Our Ref: R/2025/19/A
File No: 2026/117362
Your Ref: SSD-83899206

Advice on EIS – Mixed Use Development at Green Square Town Centre – Sites 7, 17 and 18 – SSD-83899206.

The City has reviewed the Environmental Impact Statement (EIS) and Rezoning Statement and all associated attachments and **strongly objects** to the application for the following reasons:

BARKER STREET/FELLMONGER PLACE (AT-GRADE)
TYPICAL SECTION
 SCALE 1:50

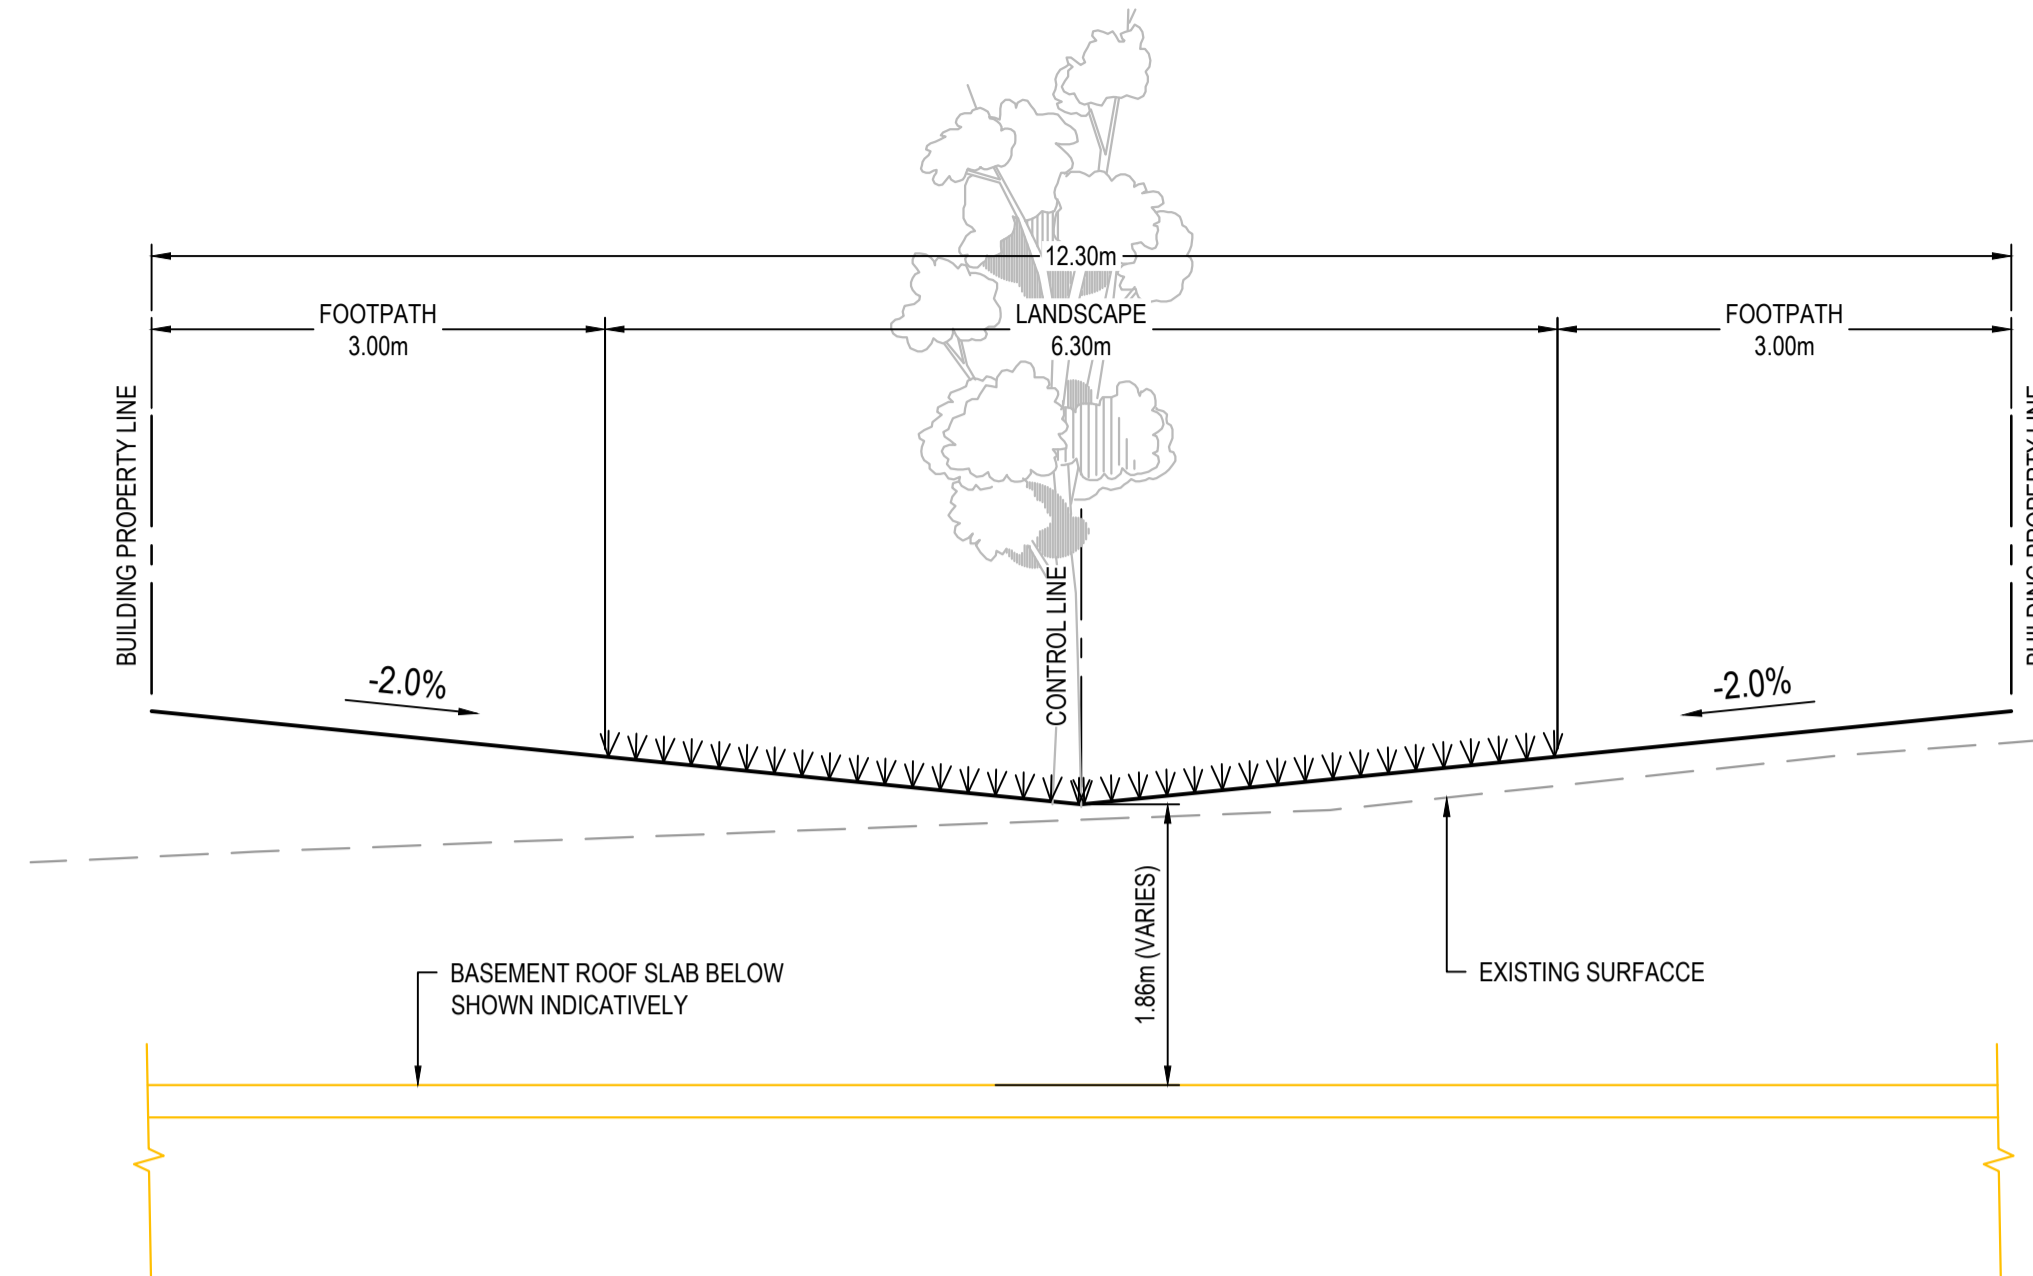
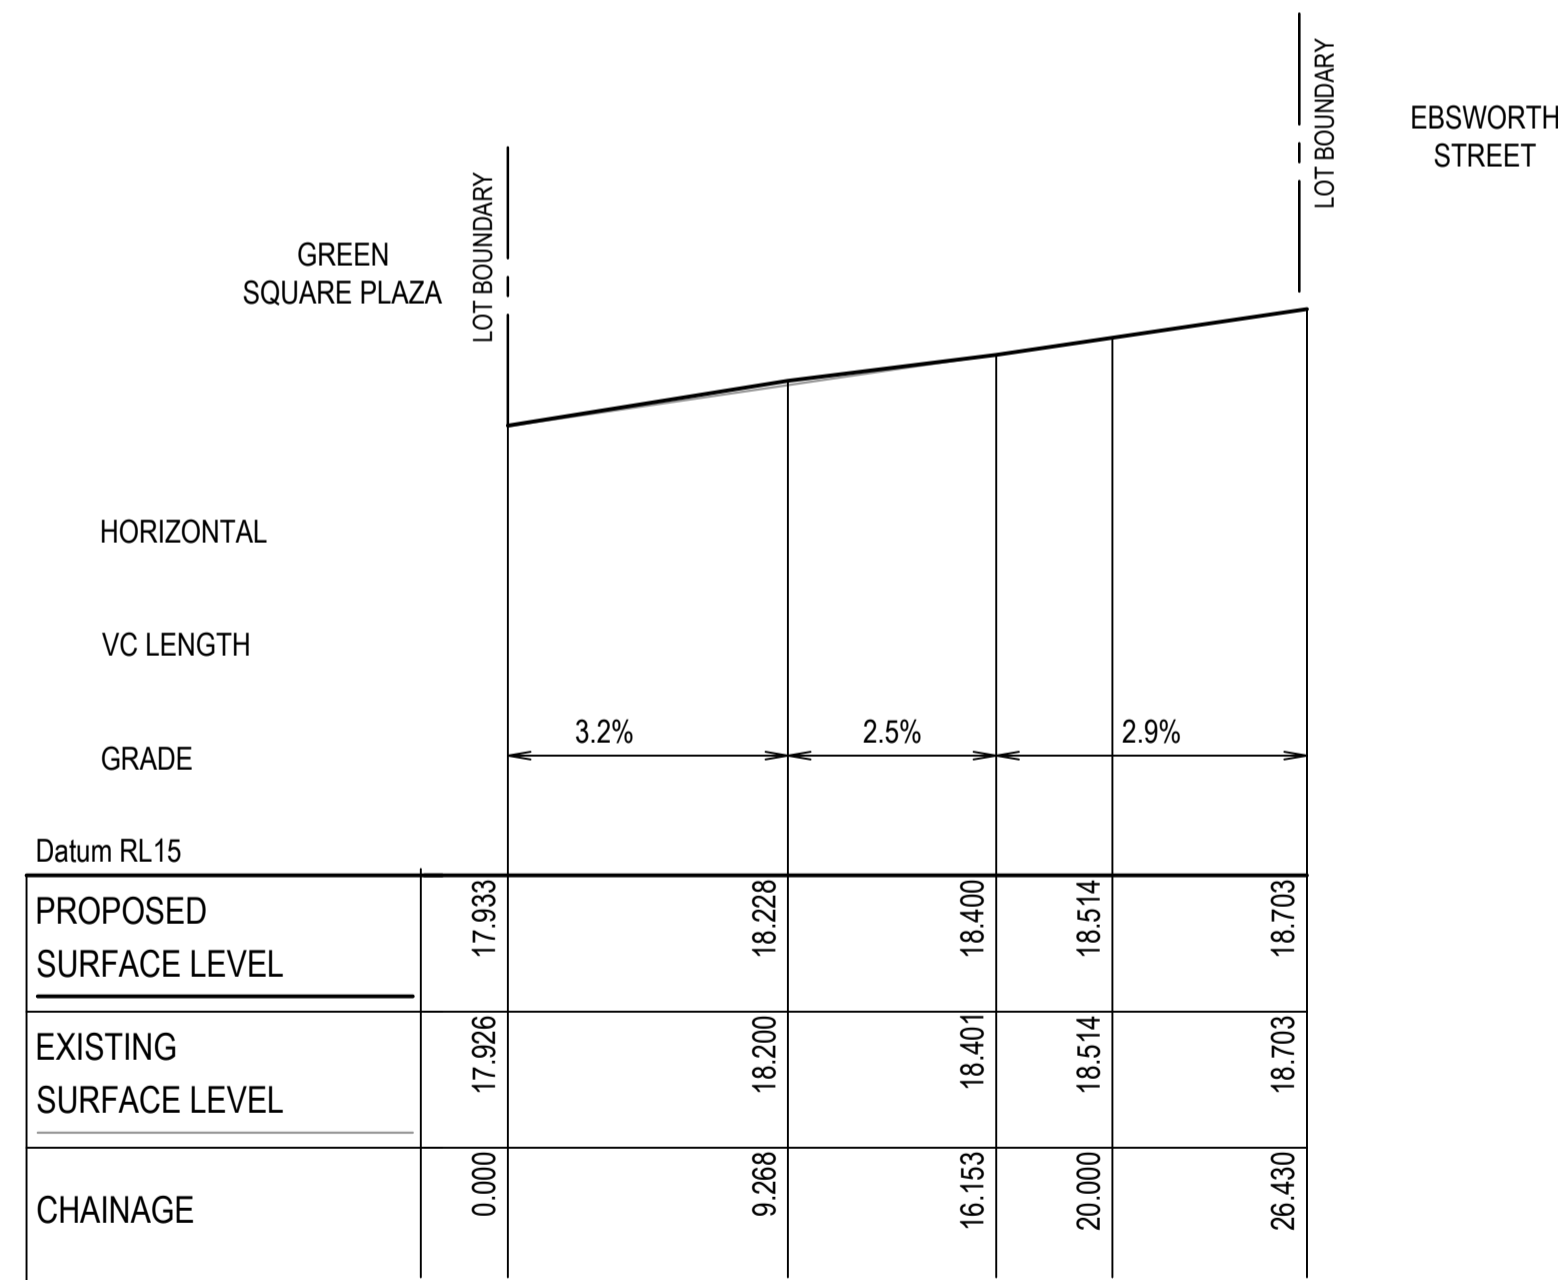
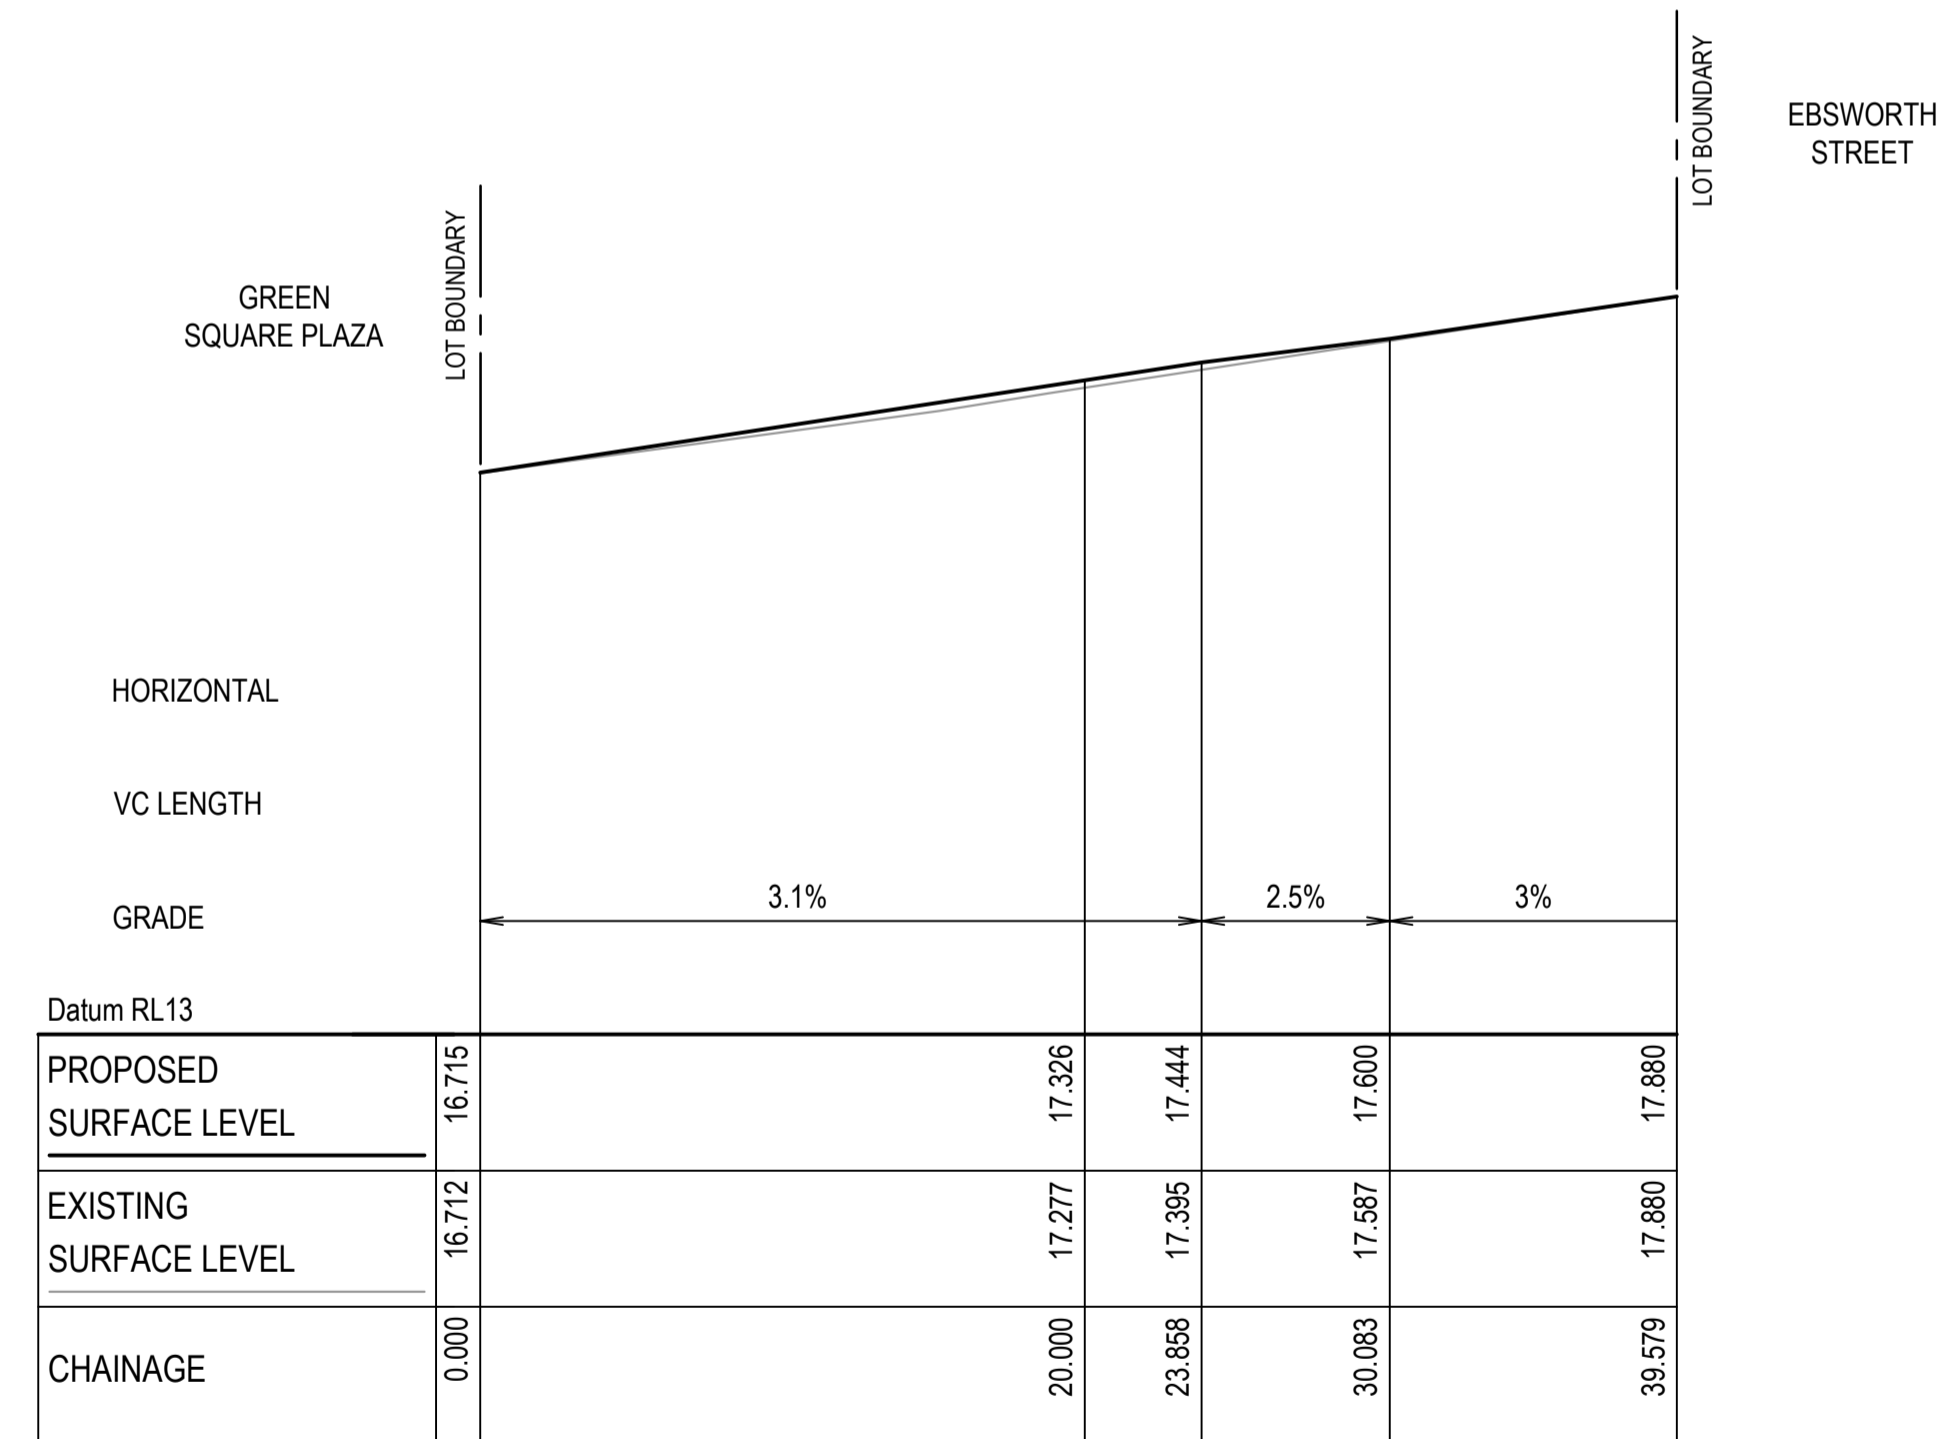
The proposed design submitted for Fellmonger Place and Barker Street are inconsistent with the approved, construction ready, design and are inconsistent with the City's future asset ownership requirements.

Overall, **the proposed design both visually and spatially privatise the spaces.** Whilst the City is open to some design development, the design should remain generally consistent with the approved designs and meet the following operational and design requirements:

- shared paths with a 4m wide continuous path of travel are to be provided on both sides of the street
- pathways are to be wide enough and unencumbered to accommodate service and emergency vehicles, including waste trucks to empty public bins and for maintenance

- a central path should be provided to allow pedestrians
- paving materials for streets should be from the standard Street Code palette to differentiate from the adjoining Library and Plaza, and to ensure no additional maintenance costs are passed on to the City
